OXFORDSHIRE COUNTY COUNCIL'S RESPONSE TO CONSULTATION ON THE FOLLOWING DEVELOPMENT PROPOSAL

Application no: 21/03177/F

Proposal: Full planning application for employment development (Use Classes E(g)(iii), B2 and/or B8) and associated parking and servicing, landscaping and associated works

Location: Axis J9 Phase 3 Howes Lane Bicester

Drawing Title:
CYCLE SHELTER DETAILS

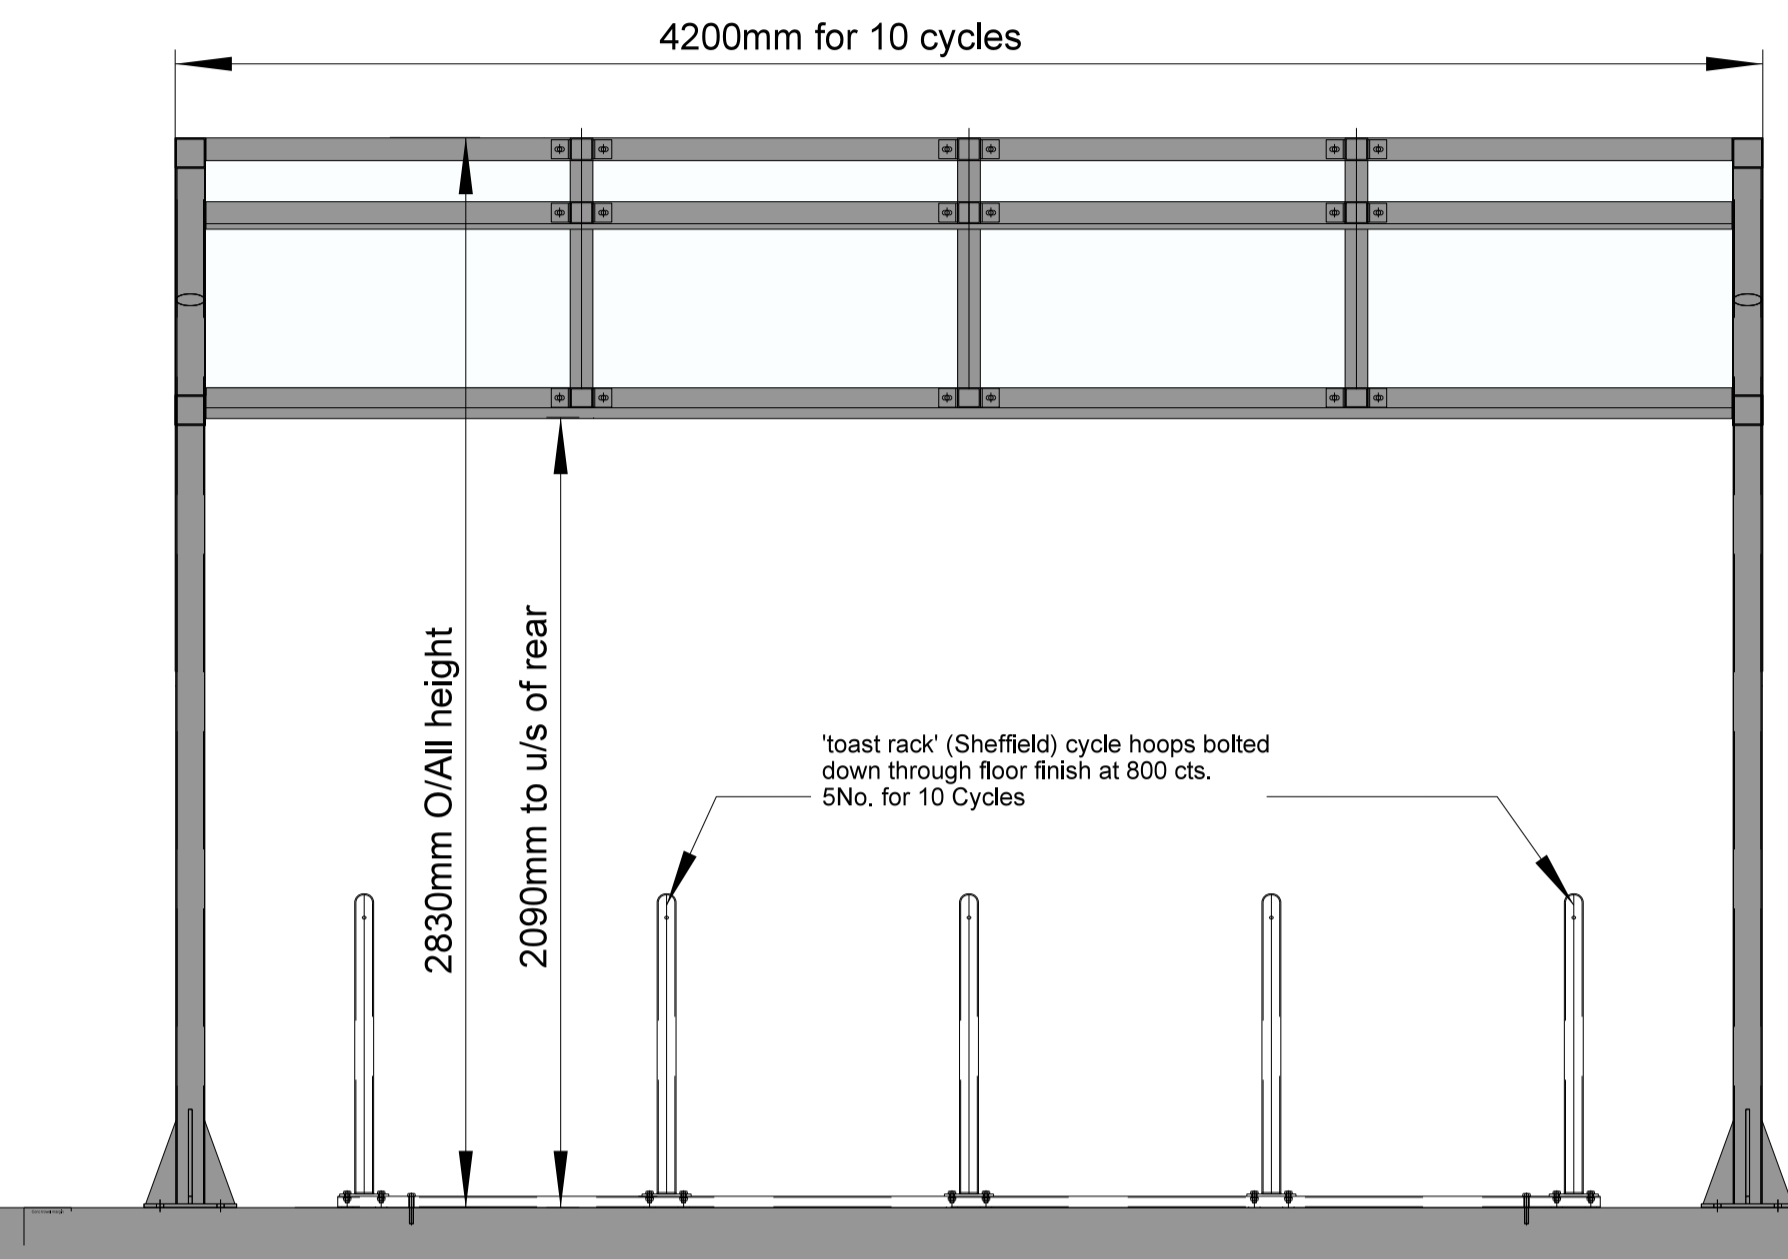
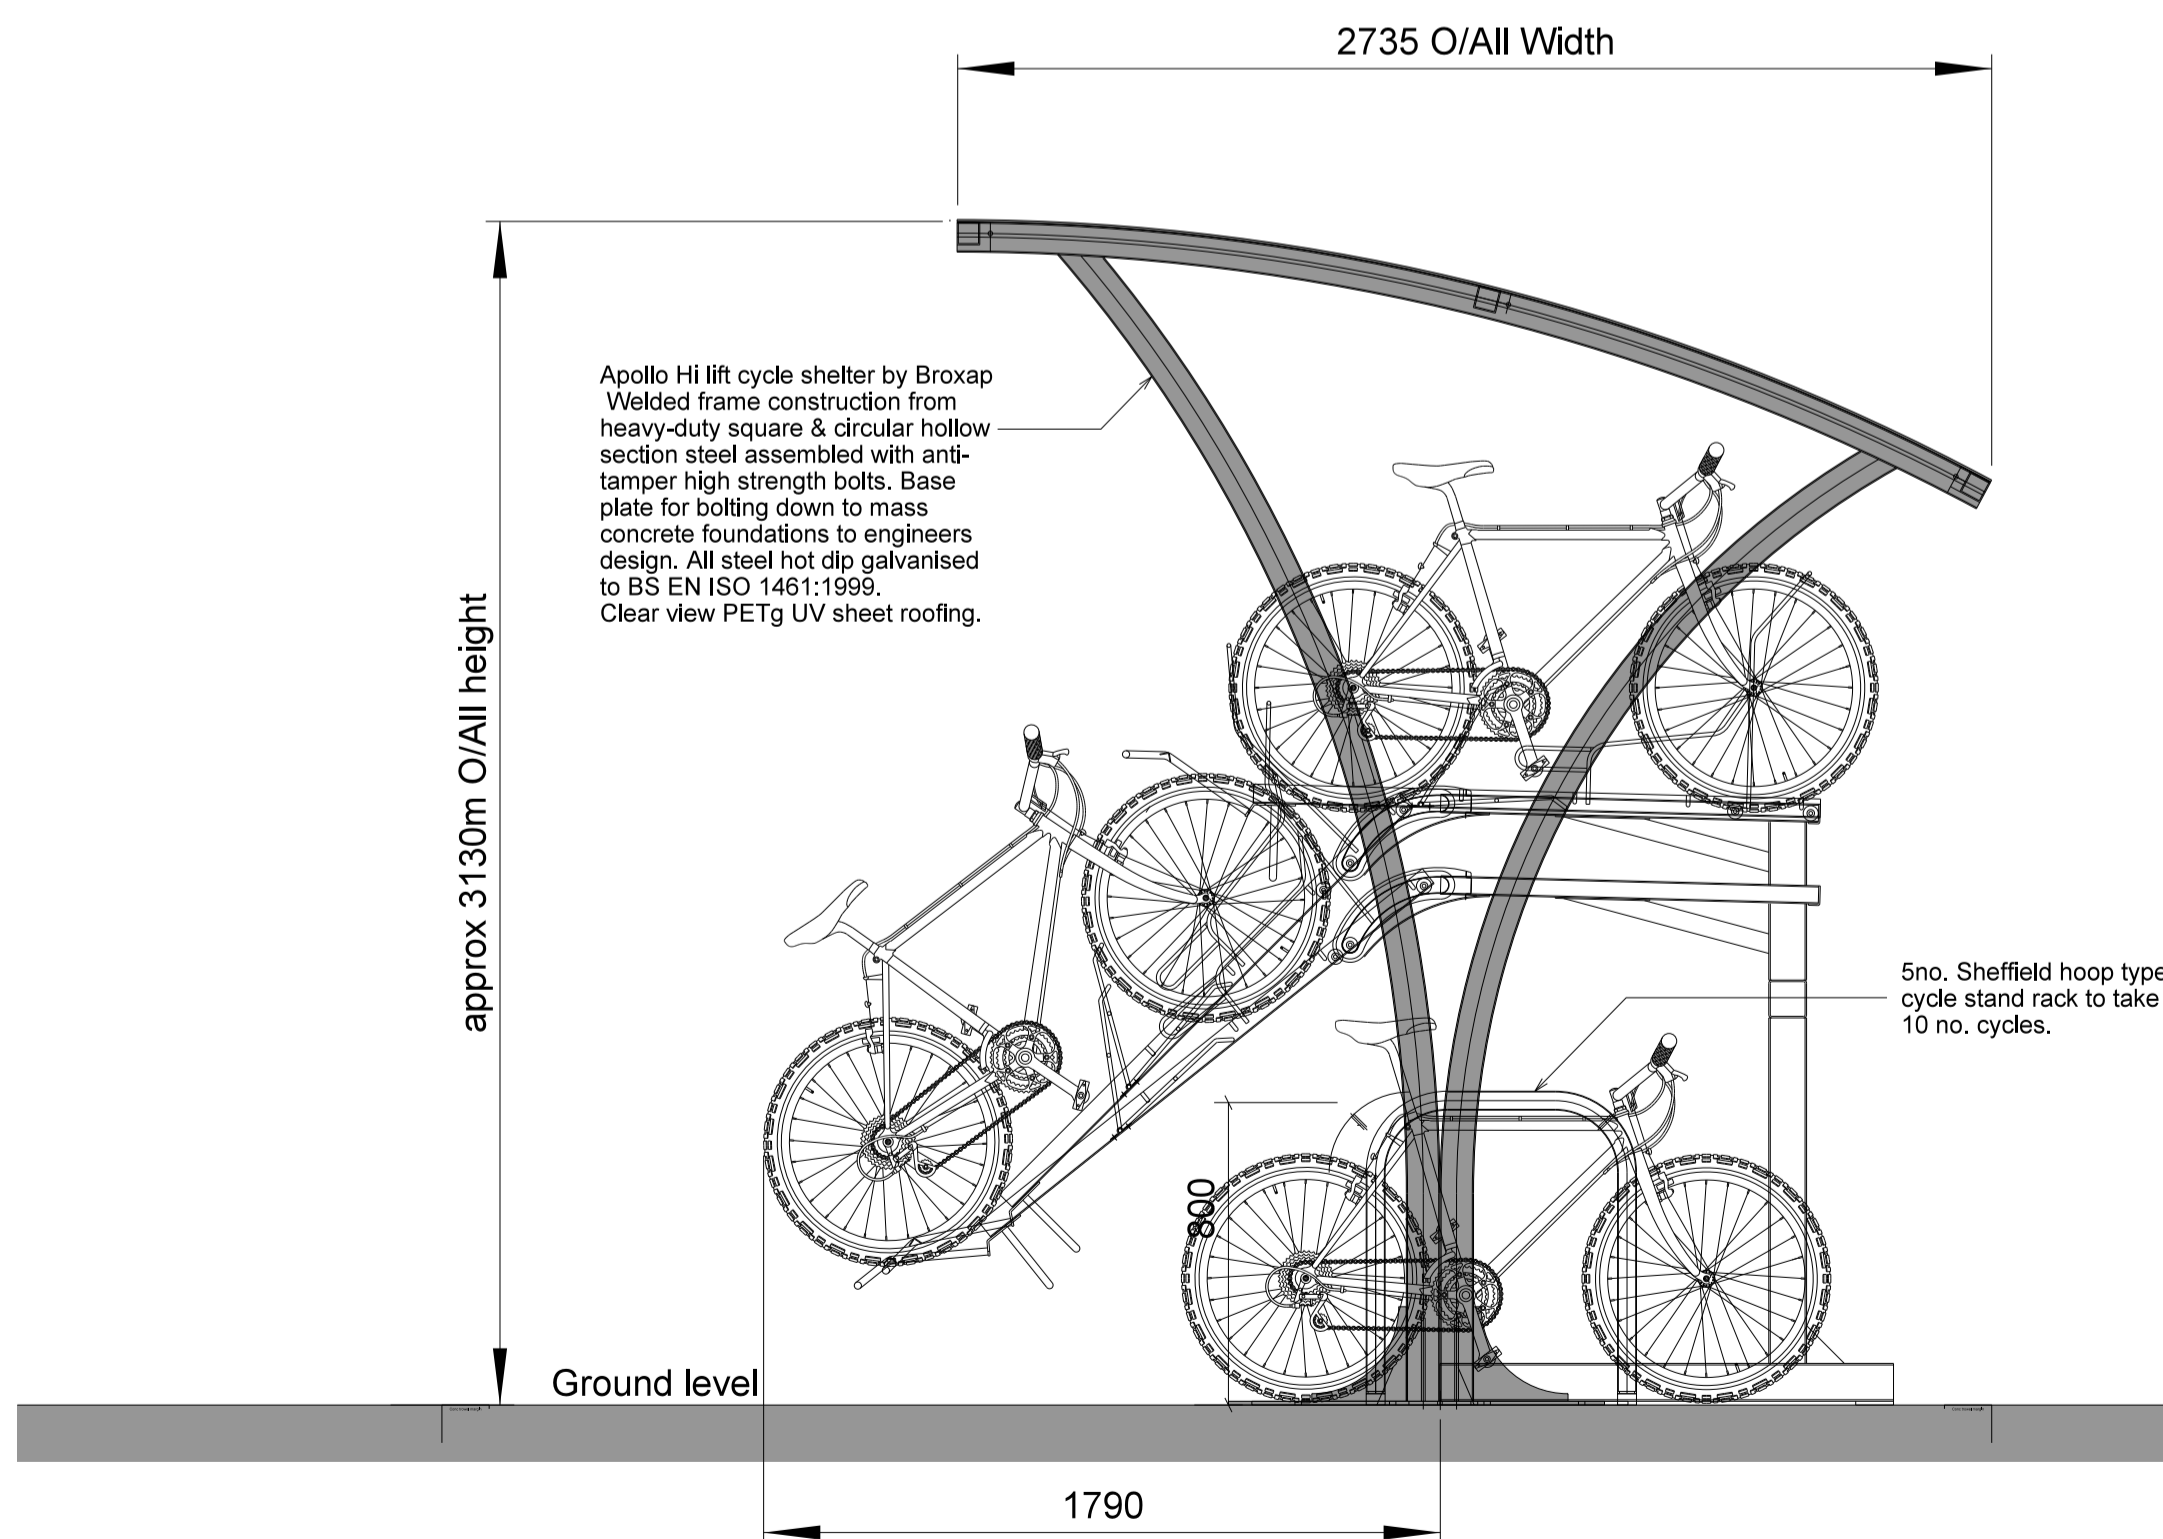
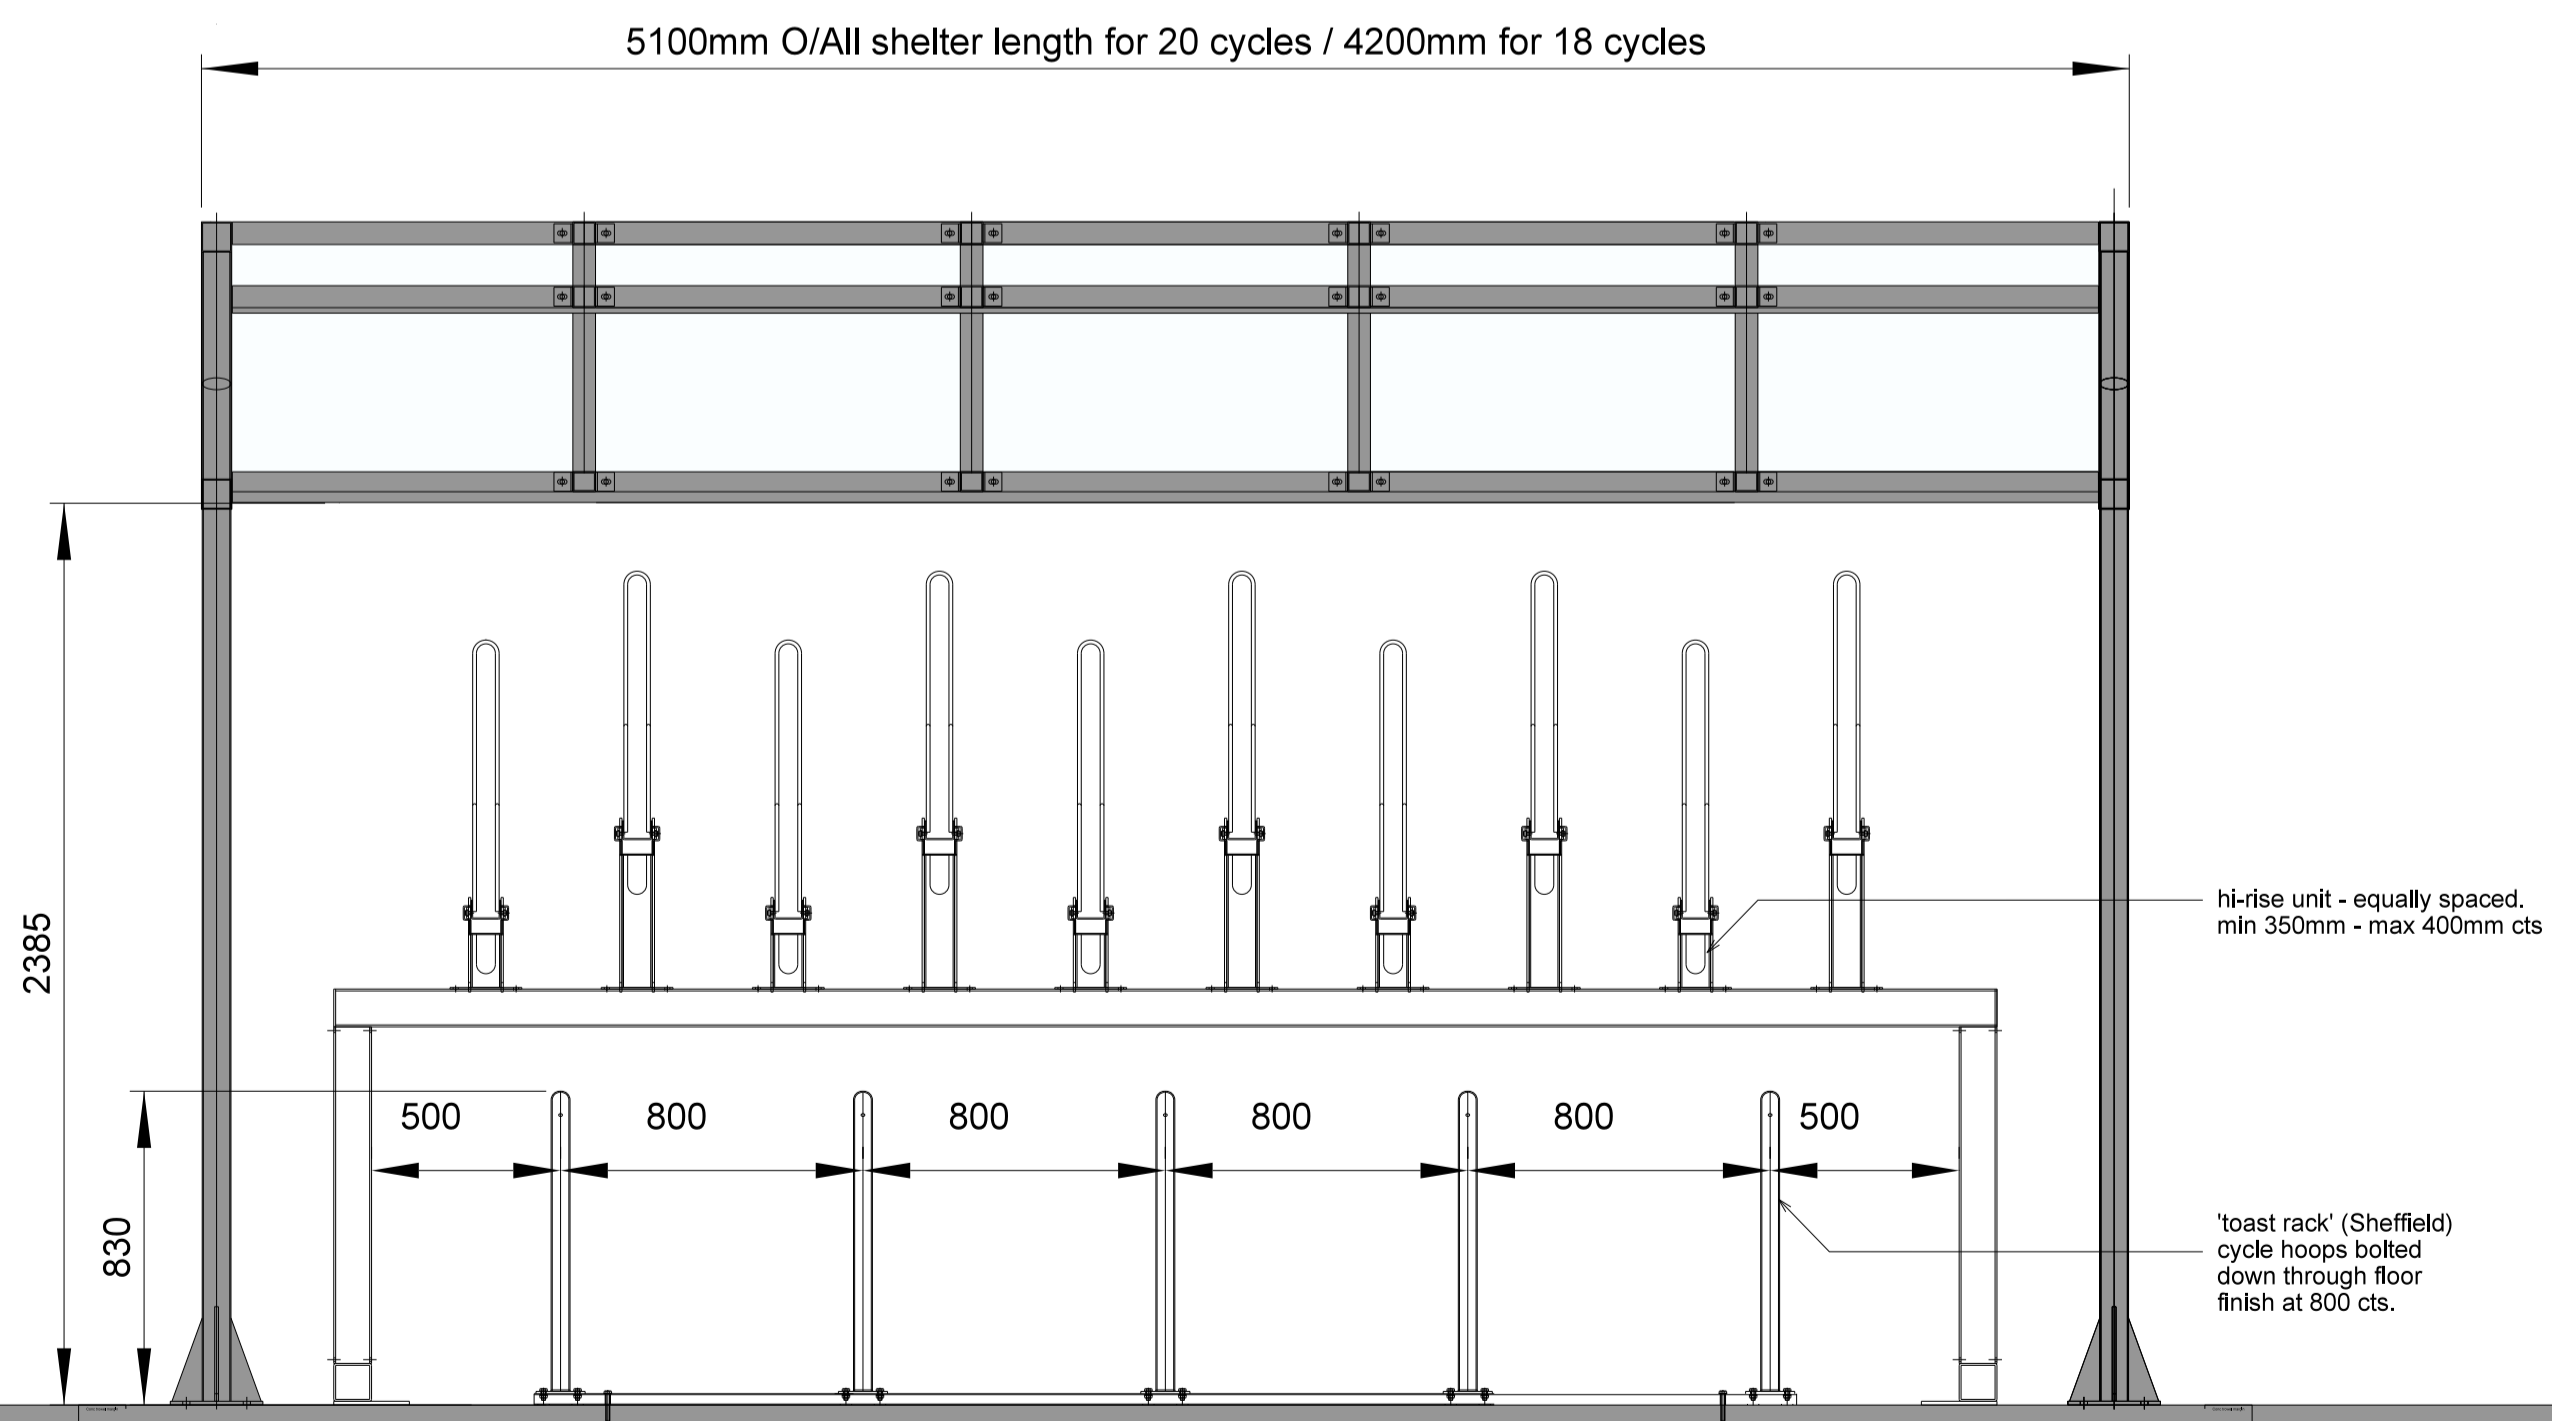
To address the placing of cycle parking within the HGV areas, white lines are proposed to demarcate a safe route for cyclists. These routes are likely to be within the manoeuvring areas for HGVs, and I can see no reason why they can't be swapped for car parking spaces – surely it is safer for car drivers to cross the HGV manoeuvring area than for cyclists.

Development shall not commence until full details of secure covered cycle parking located away from goods vehicle manoeuvring areas and close to the main entrance of each building have been submitted to and approved in writing by the local planning authority. Thereafter and prior to first occupation, the approved cycle parking shall be delivered and thereafter maintained in accordance with the approved details.
